From: Holmstrom, Rick <HolmstR@wsdot.wa.gov>
Sent: Monday, April 14, 2014 3:30 PM
To: Seaward, Mike
Cc: Lindsey Ozbolt
Subject: FW: Notice of Application - Butler Rezone RZ-14-00001
Attachments: RZ-14-00001 Butler Notice of Application memo.pdf; RZ-14-00001 Butler Application Rezone.pdf; RZ-14-00001 Butler Application SEPA.pdf; RZ-14-00001 Butler Project Proposal.pdf

Cc: Lindsey Ozbolt; Doc Hansen; Jeff Watson; 'essenb25@yahoo.com'; '970selfstorage@gmail.com'; Brad & Vicki Butler (sailfish2@gmail.com)
Subject: Notice of Application - Butler Rezone RZ-14-00001

SITE PLAN  
VIEW  
2013-062

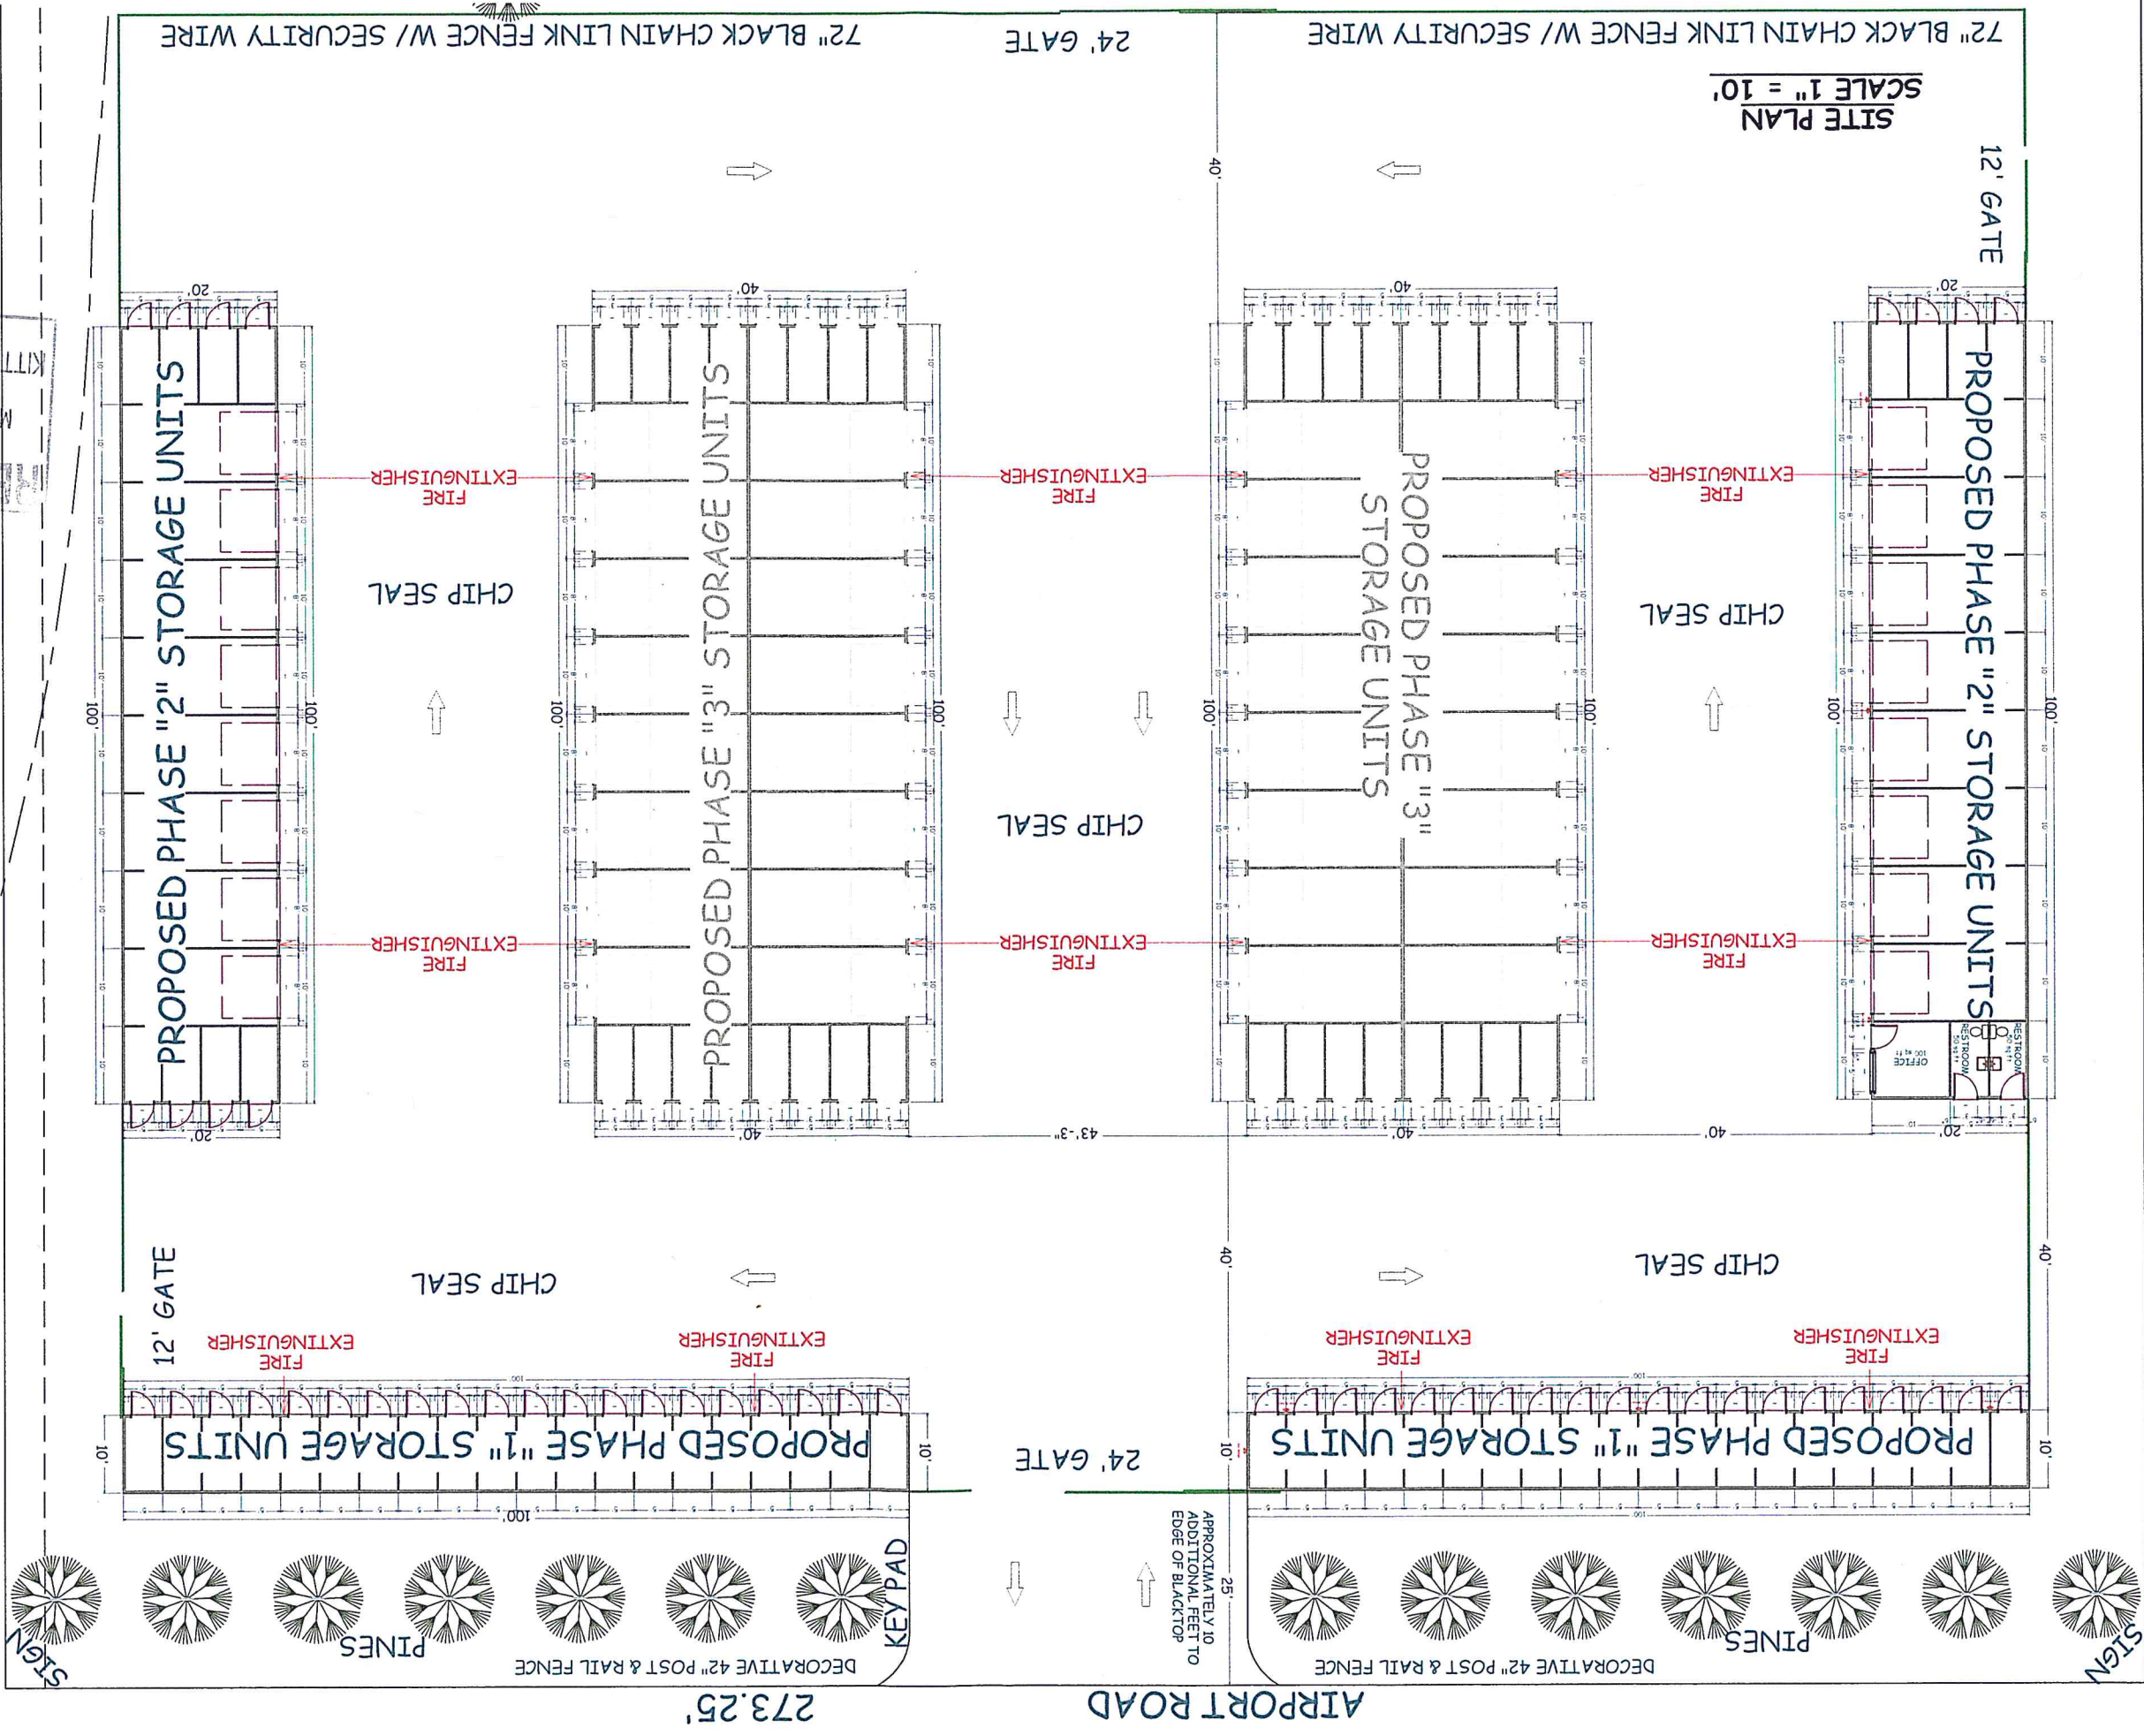
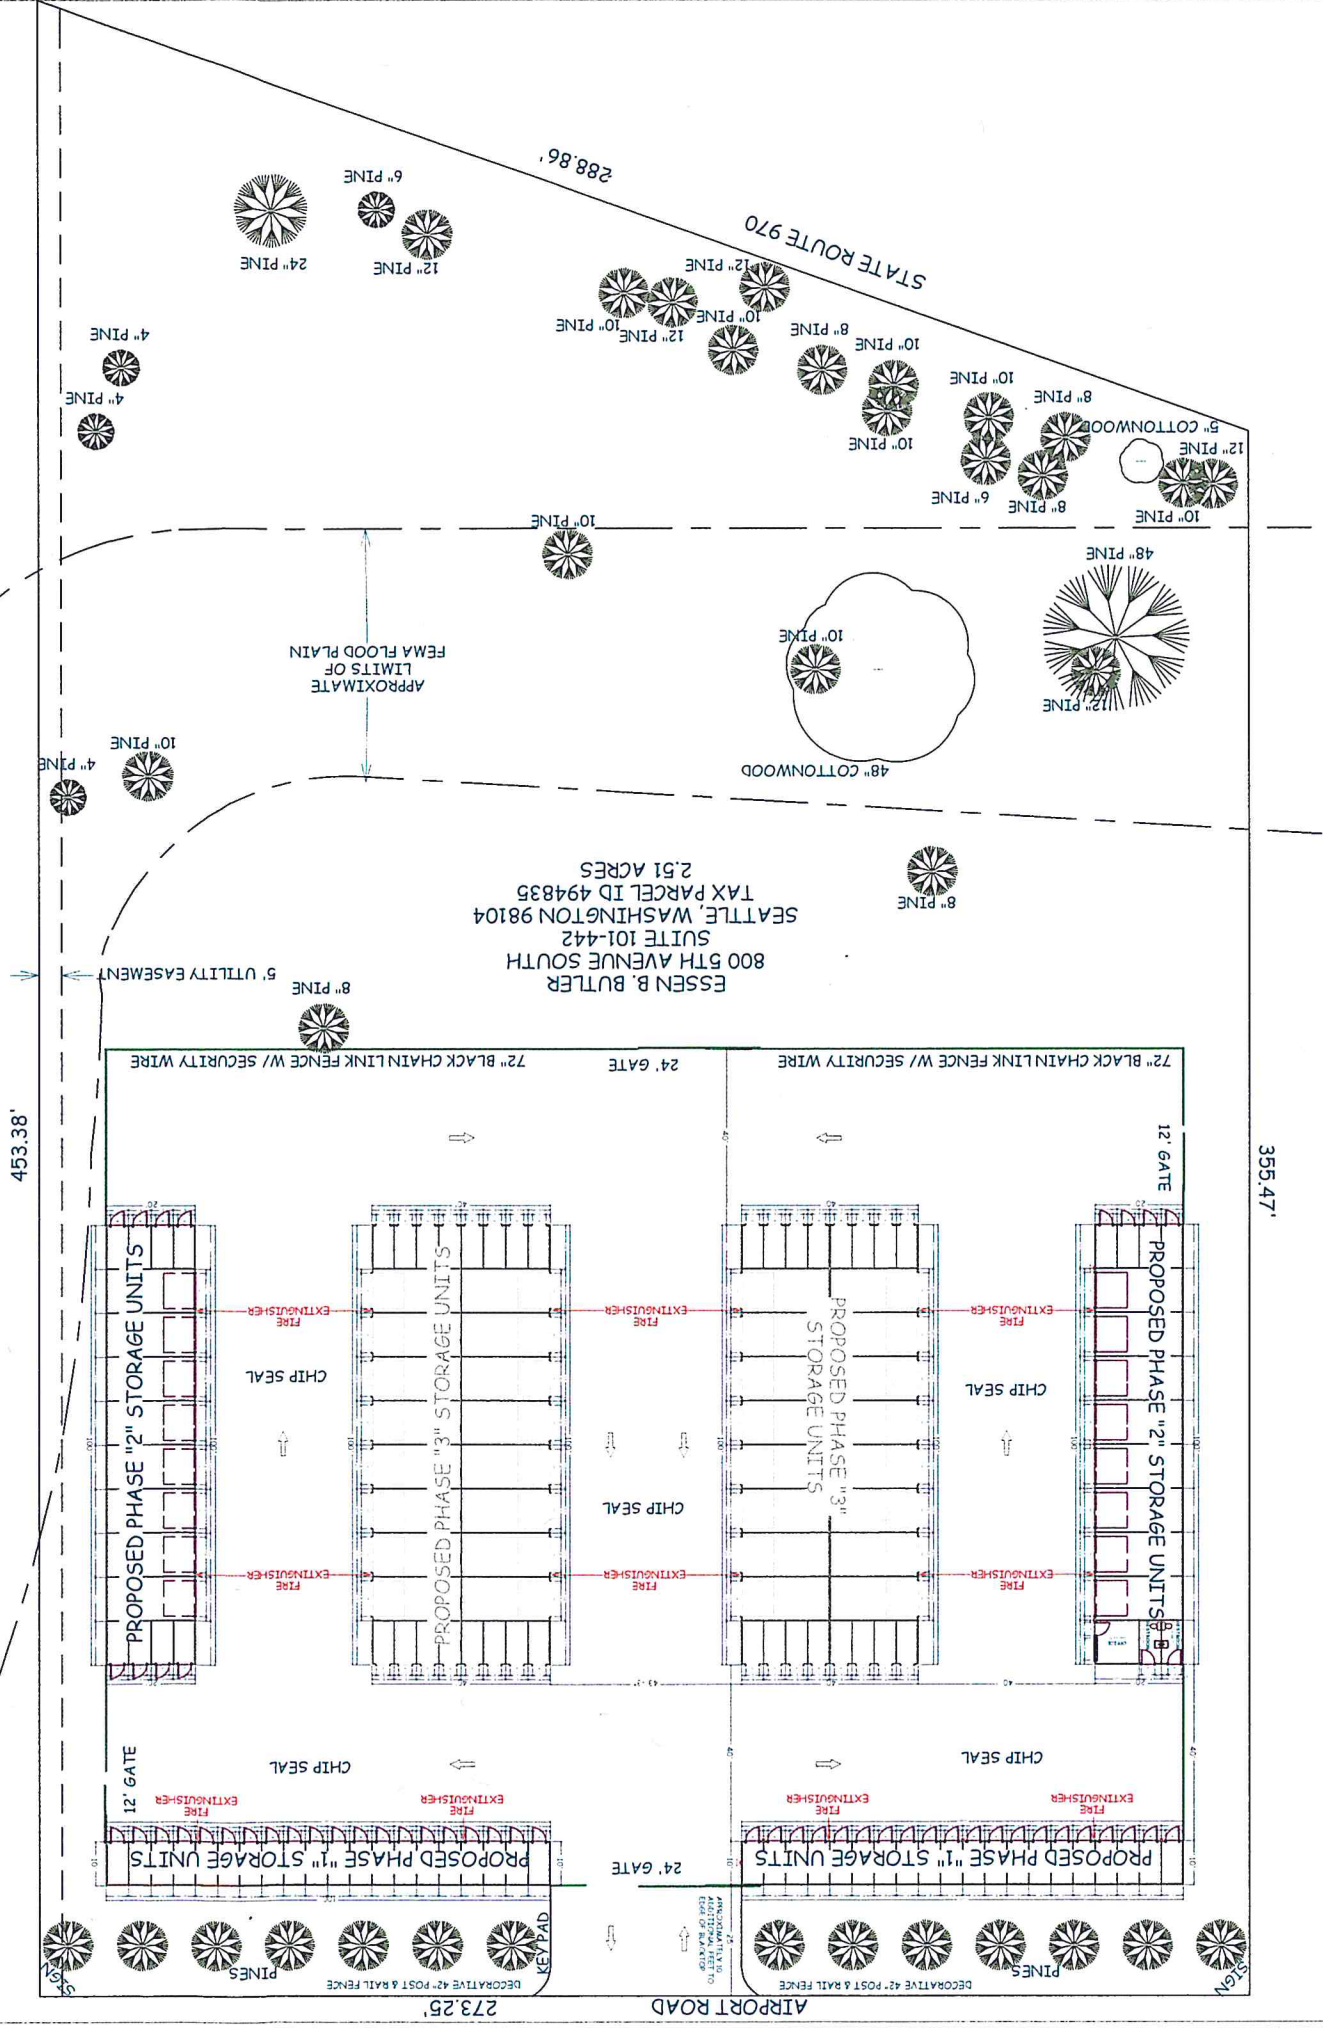
Mike-gather the info on this please and prepare our response. It is on the 903 spur. I spoke to Lindsey late last week-the proponenet has access to Airport road. They should not plan for access off the spur, until a TWTL is built.
